GLYN RHONWY PUMPED STORAGE SCHEME

PROJECT REFERENCE: EN 010072

NRW provides the following comments on the interested parties' responses to the ExA's second written questions, applicant's final draft DCO, the updated draft management plans, and your rule 17 letters dated 27th June 2016.

Figure 1 – Schematic flowchart demonstrating the processes involved in slate management

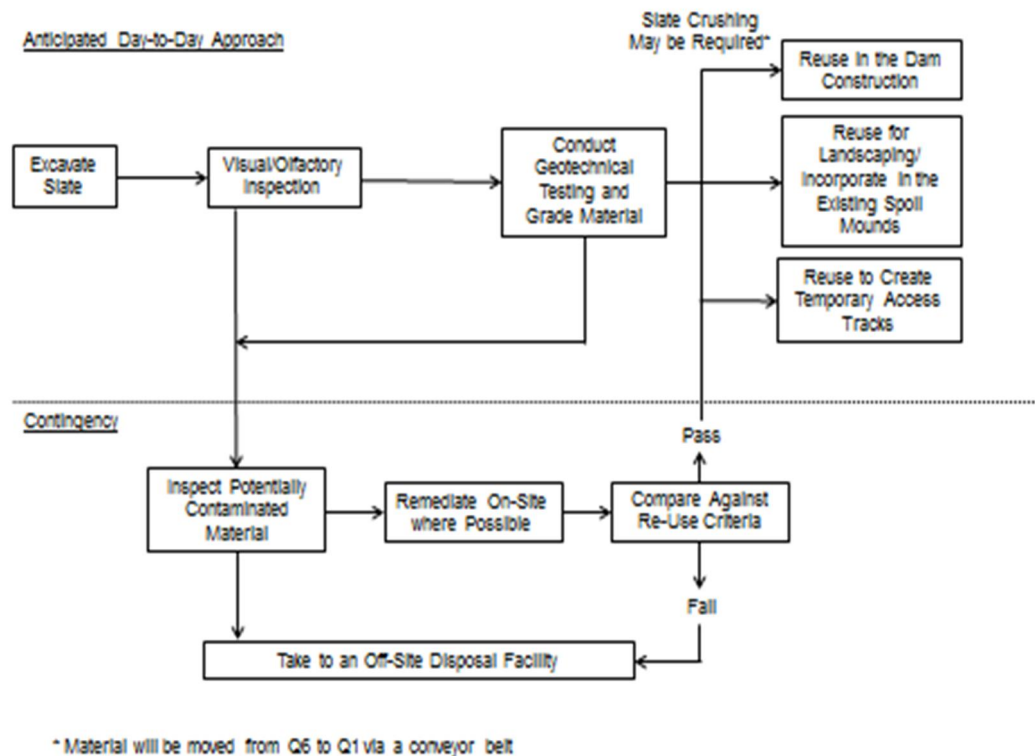
Our main concern relates to the management of slate waste material. We have maintained from the outset that there needs to be a comprehensive methodology for managing slate fines runoff. We would prefer to see the plan in more detail, cross-referenced with the Pollution Prevention Plan.
